Recommendation Report for Planning Permission for Works or Extension to a Dwelling

REF NO: FP/18/21/HH

LOCATION: 30 Sea Drive
Felpham
PO22 7NE

PROPOSAL: Two storey rear extension and balcony, garage conversion & single storey garden room to rear. Alterations to external materials.

DRAWING  
**PROPOSED PLANS**  
DRAWING No  
**331/04**  
SCALE 1:100  
DATE JAN 2021  
DRAWN LA  
CHECKED

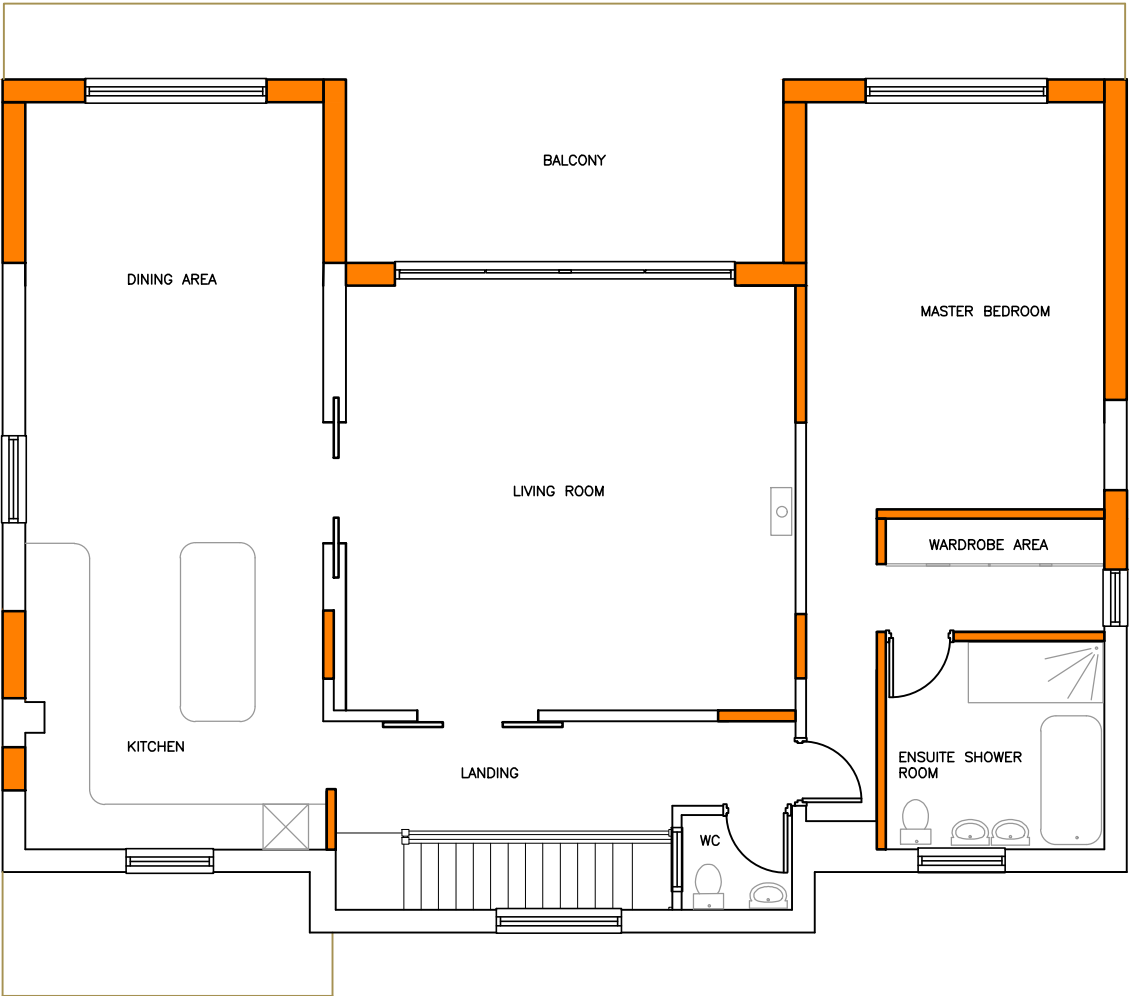
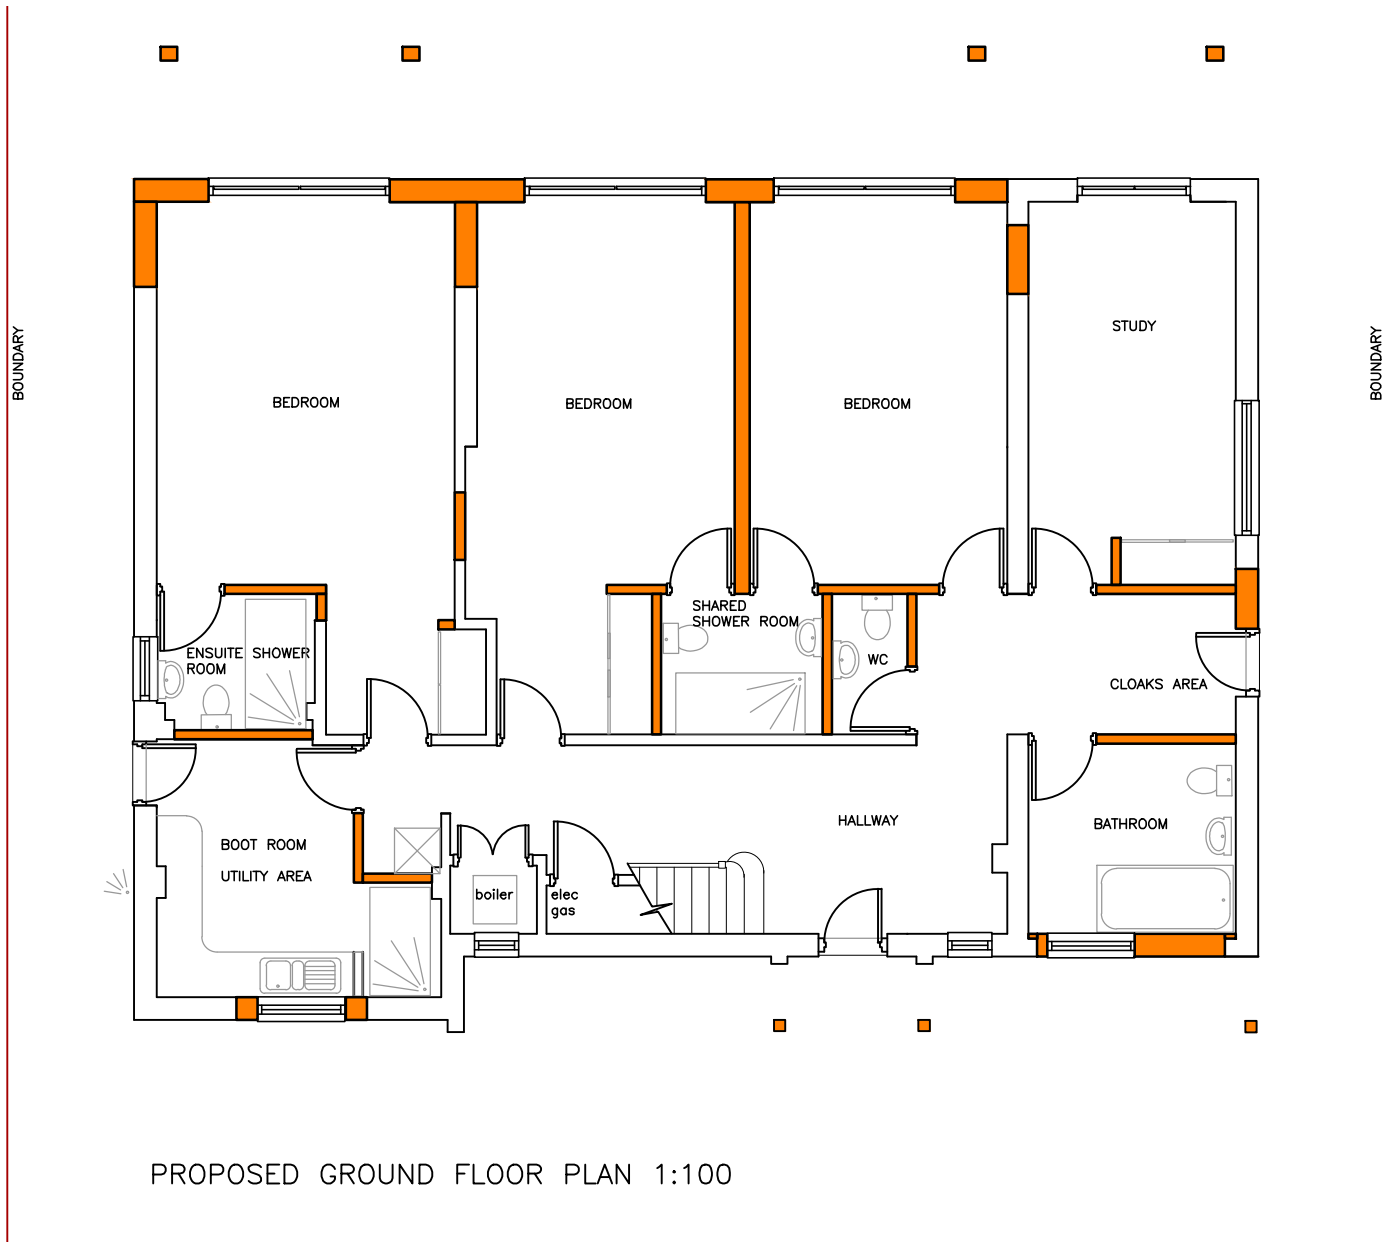
The dwelling has 2 existing balconies to the rear with a ground floor conservatory to the centre of the dwelling. The ground floor addition will be removed and first floor extensions will be constructed to the east and west side. A new balcony will be constructed which will run along the full rear of the dwelling.

There is an existing rear gable addition to the eastern side and this will be extended in depth by around 2.25m. An additional first floor extension will be constructed to the western side with a depth of around 4.1m.

The building line to the centre of the dwelling will be set back behind the extensions and as such a balcony will be formed to the centre with a depth of 3.3m. As a result of its siting of the balcony between the extensions, views towards to the neighbouring dwellings are largely restricted.

DRAWING
**PROPOSED
ELEVATIONS**
DRAWING No
331/05
REVISION
SCALE 1:100
DATE JAN 2021
DRAWN LA
CHECKED

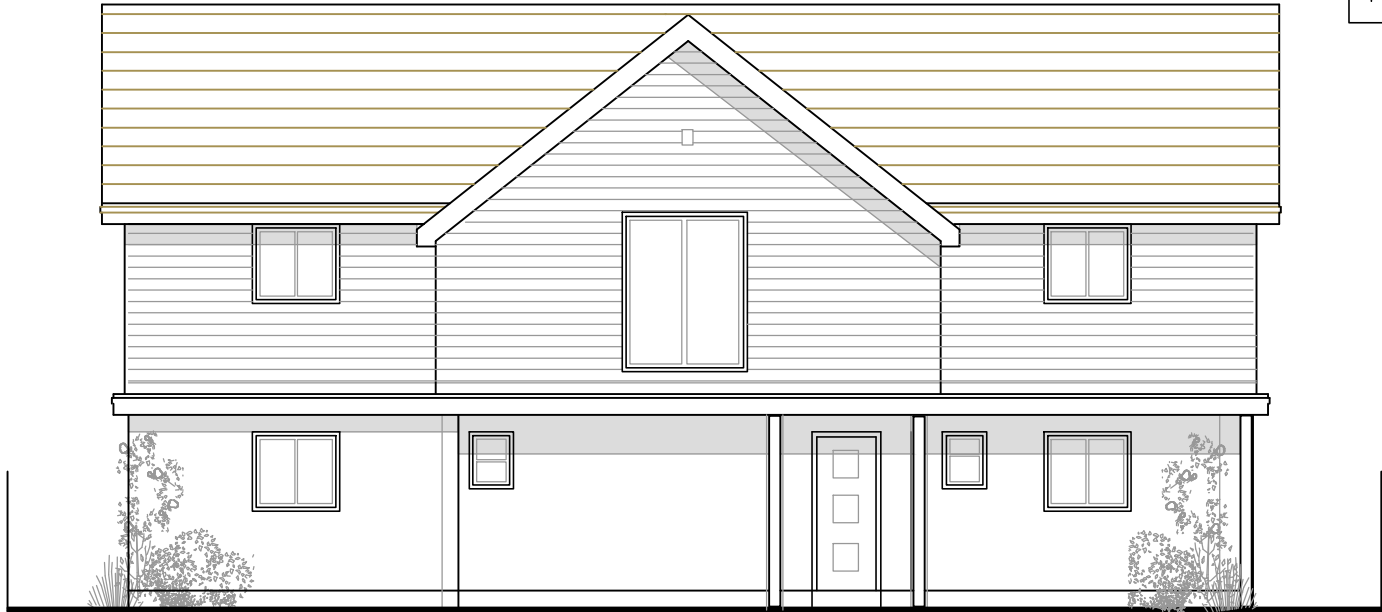
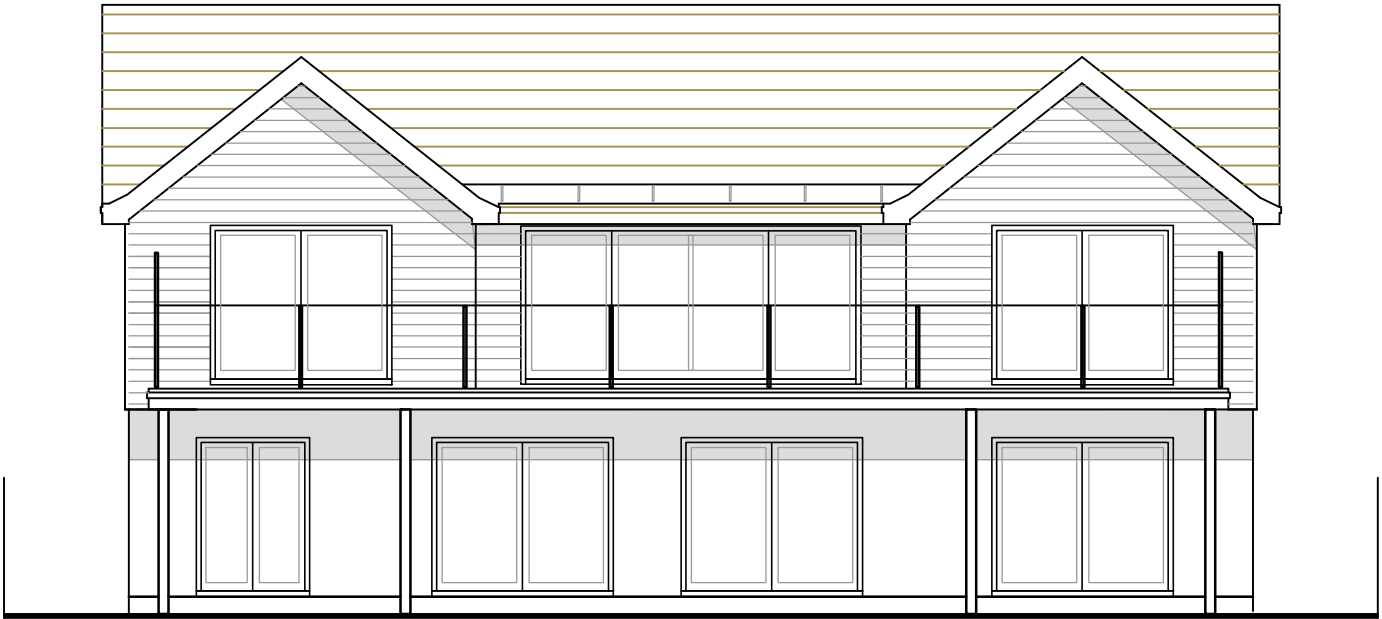
There will be a small balcony which will run along the rear of the dwelling and extensions with a depth of approximately 1m. The plans do however demonstrate screening to a height of 1.8m to the east and western sides. This is considered sufficient to ensure the additions does not give rise to adverse overlooking.

- 3 The balcony screening shall be constructed to the eastern and western side of the balcony to a height of 1.7m as shown on the approved plan 'Proposed Elevations - 331/05' . It shall be installed prior to the first use of the balcony and be retained thereafter in perpetuity.

DRAWING
**PROPOSED
GARDEN ROOM**
DRAWING No REVISION
331/07
SCALE 1:100 DRAWN LA
DATE JAN 2021 CHECKED

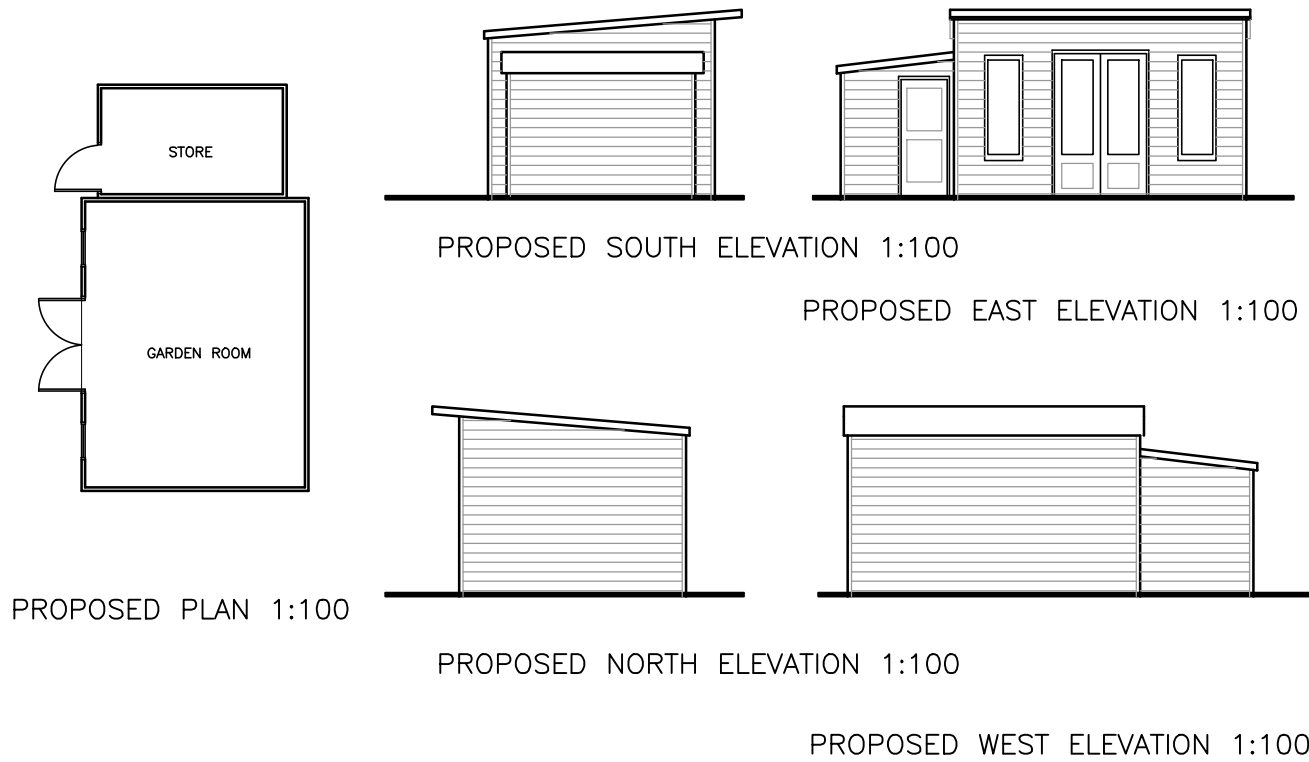
There is a garden room and store proposed to the west side of the rear garden. This will have a total length of around 5.3m and depth of 3m. This will have a maximum height of 2.5m. The outbuilding

appears to fall in permitted development and due to its size is not considered to result in harm upon amenity.
